We acknowledge the comments made by the Applicant in the document 'The Applicants' Responses to Relevant Representations' (Application Reference 10.3) in response to our submitted Relevant Representations. We can confirm that whilst discussions on reaching a voluntary agreement have continued since we made that submission, a binding agreement on the land has not been completed. We continue to object therefore to the Proposed Development. If the Applicant's assurances and proposed mitigations become legally binding we may then be in a position to withdraw our application. Our Relevant Representation is resubmitted as an attachment to this Written Representation.

Relevant Representation (Objection) on behalf of Albanwise Limited regarding:

Proposed Dogger Bank South Offshore Wind Farms (the “Projects”)

Proposed Dogger Bank South Offshore Wind Farms Order (the “Order”)

DRAWING NUMBER: 005028746-01 **PAGE NUMBER:** 19 of 20
Application Reference: 2.7 / APPP Regulations: SC(6)

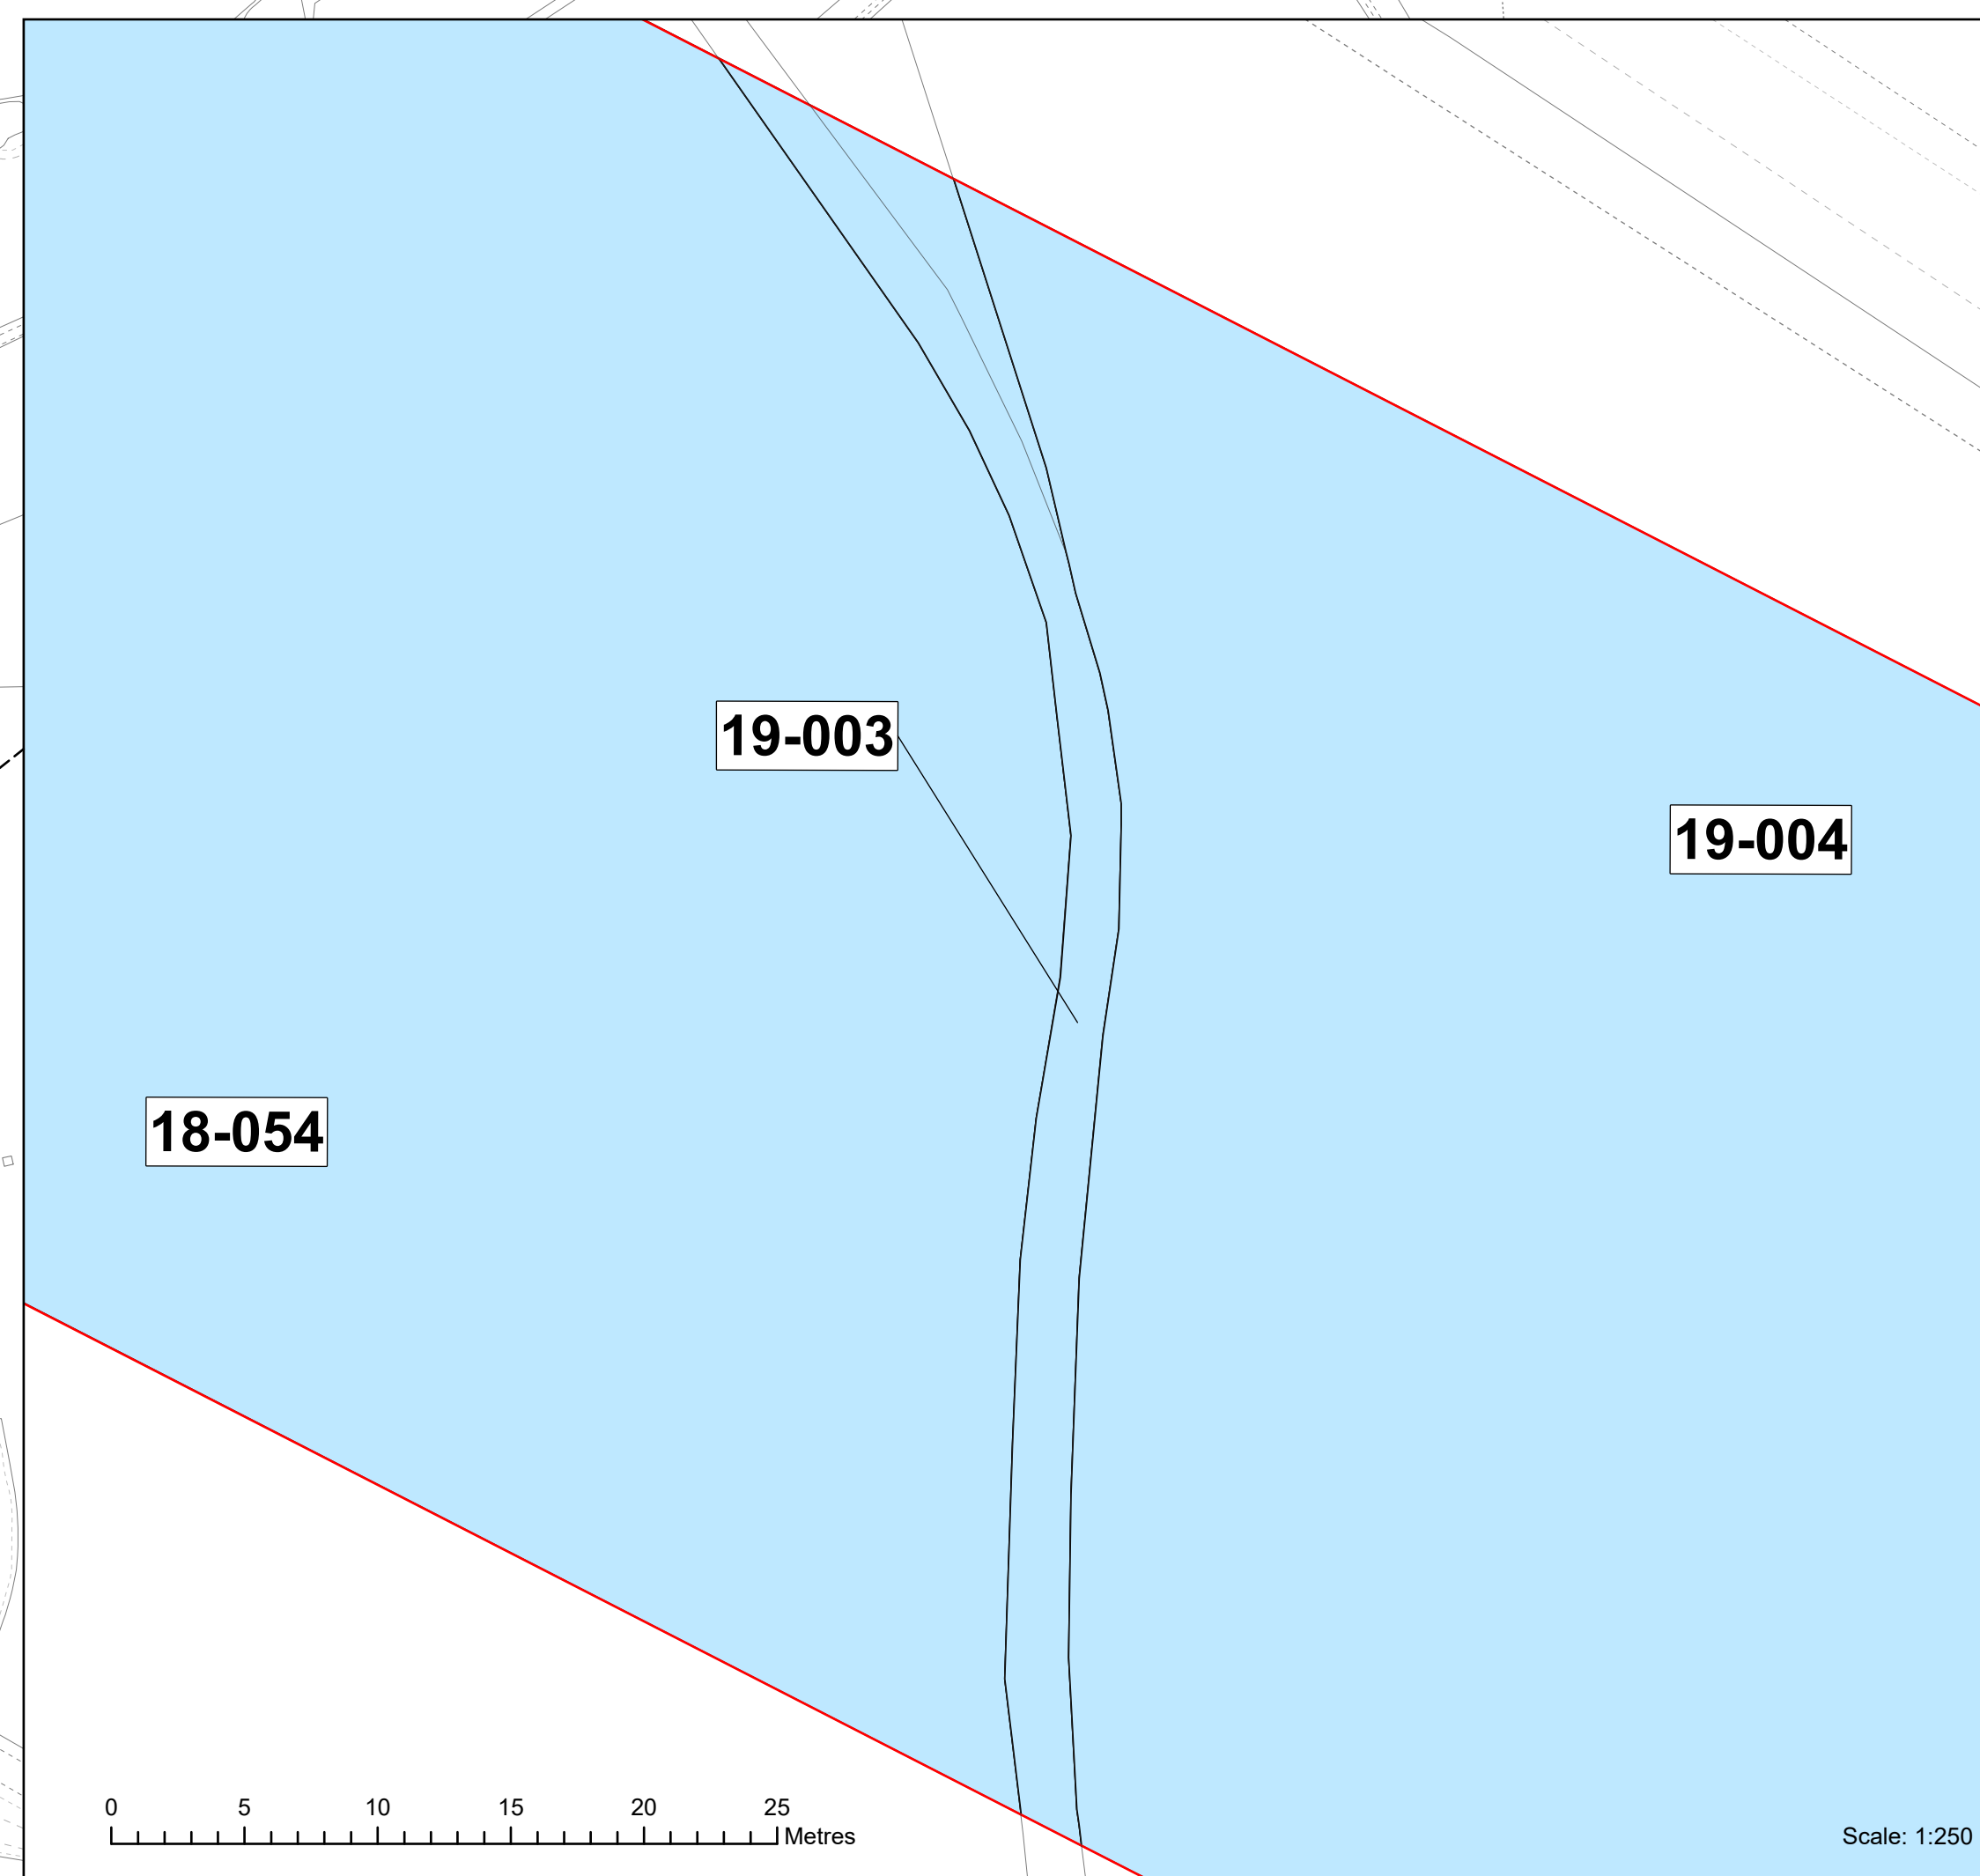
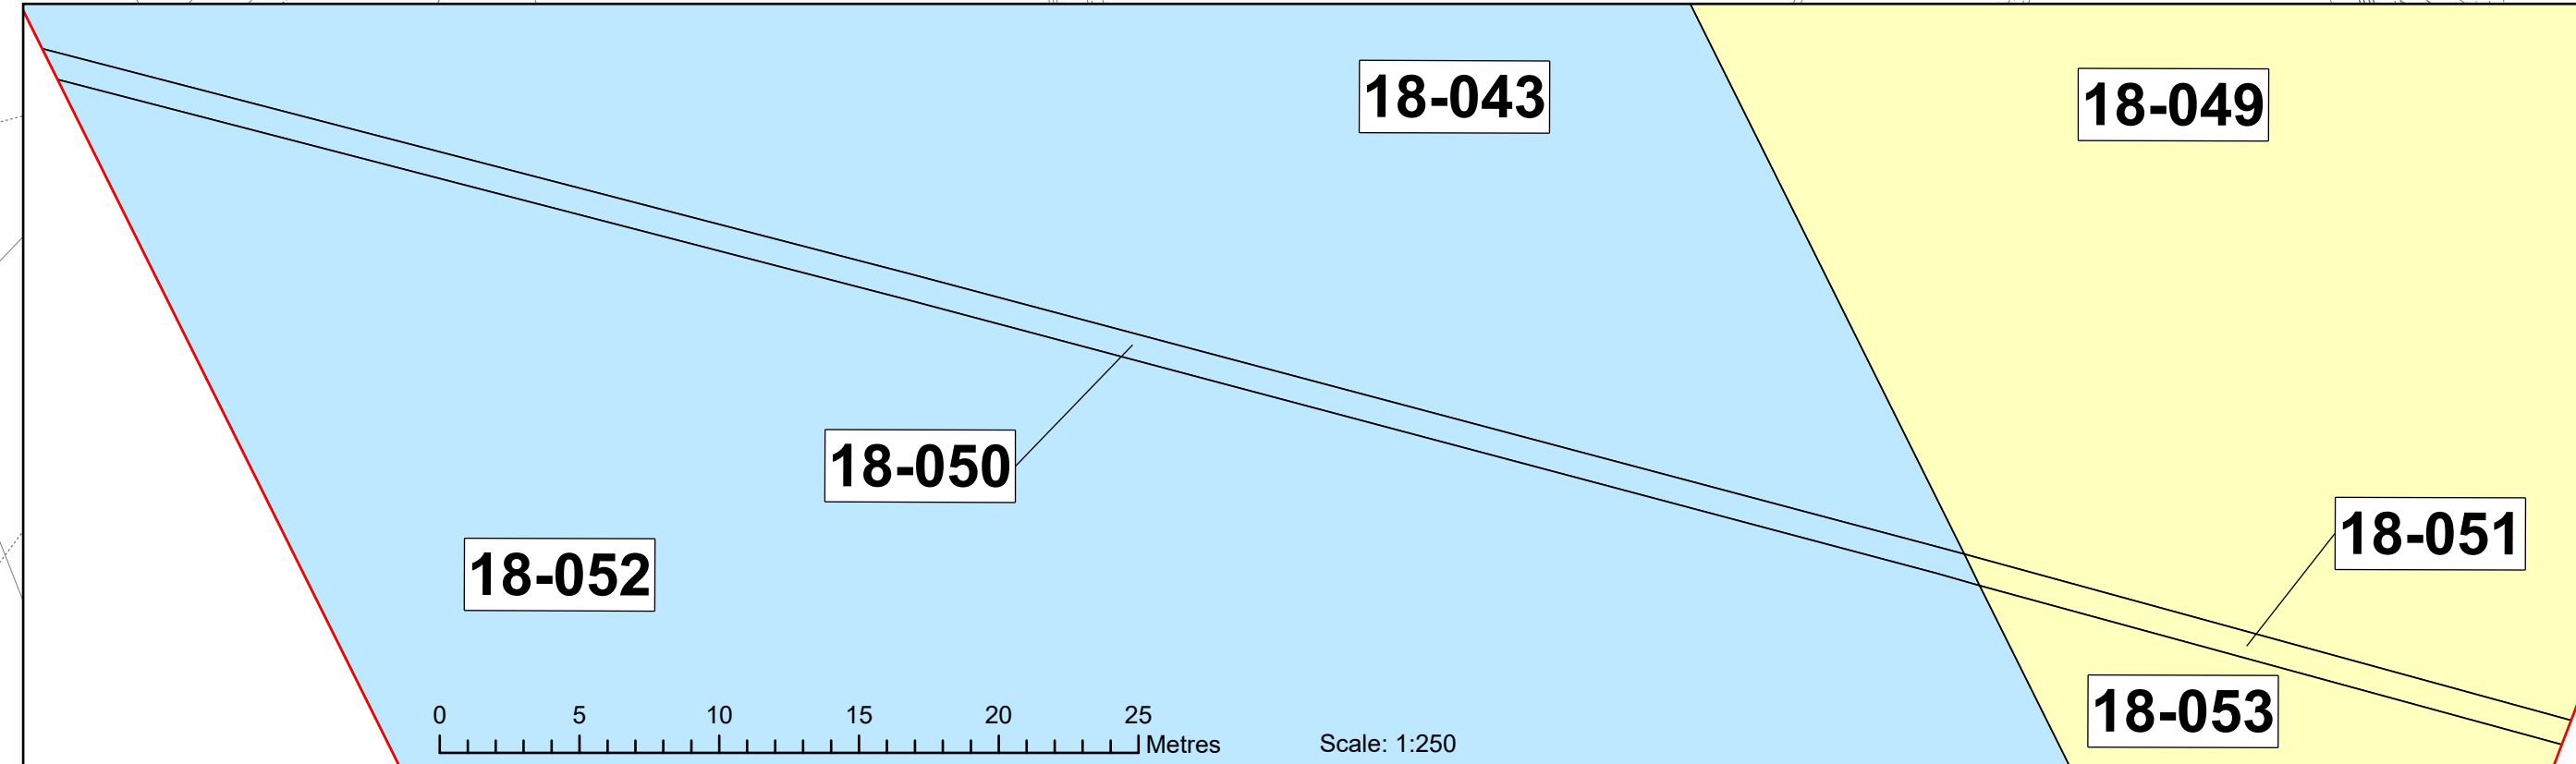
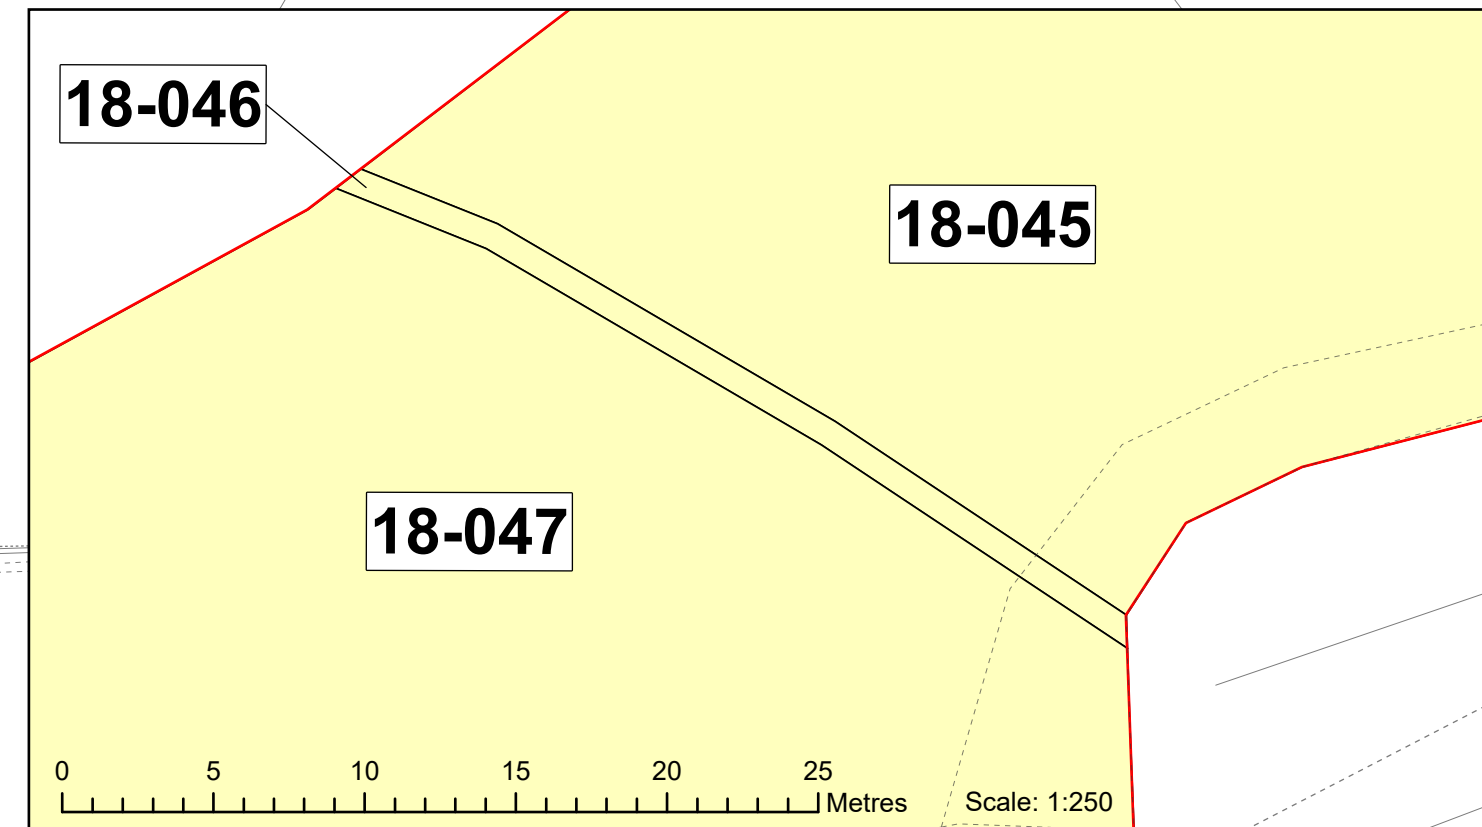
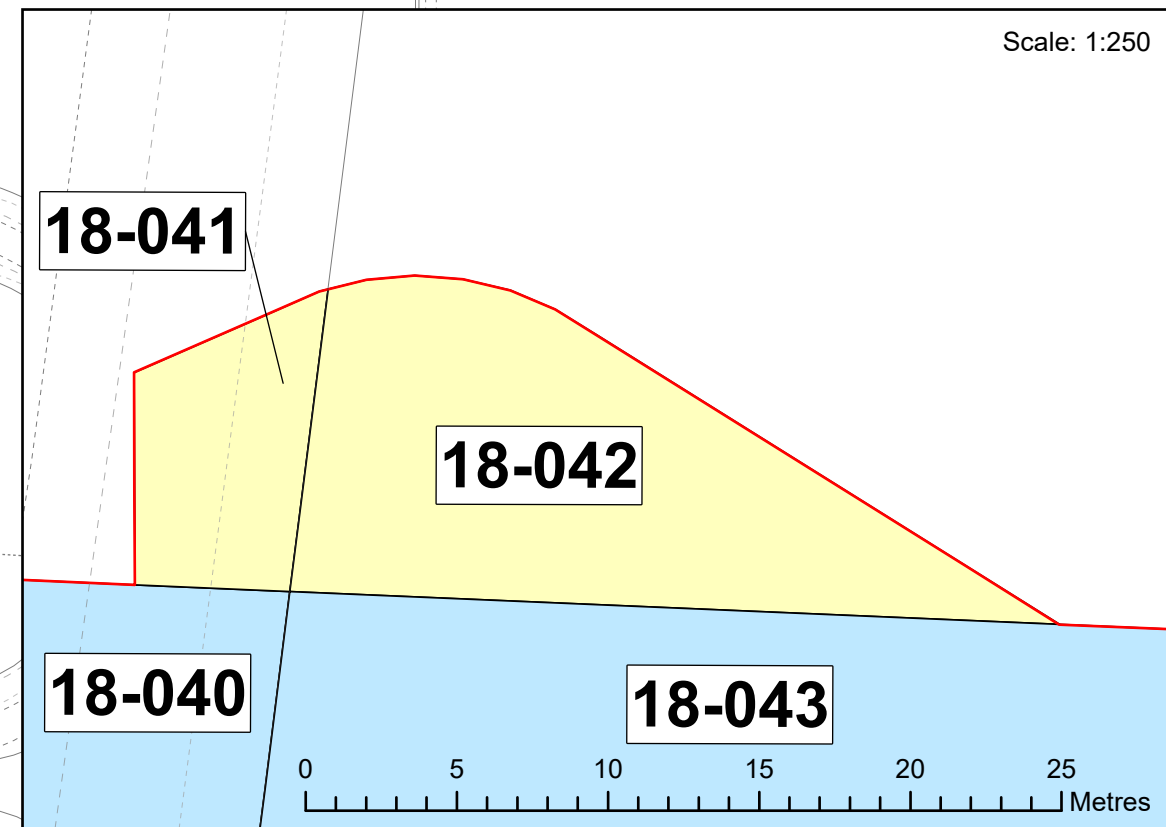
- a. the splitting of the cable route (Works no 32B) across twin paths, involving (but not limited to) land plots 18-054, 18-052, 19-003 and 19-007. Separating the cables by such a distance greatly increases the overall extents of the impact in the land and diminishes the prospects for further utilization of the land for any business interest of AWEL;
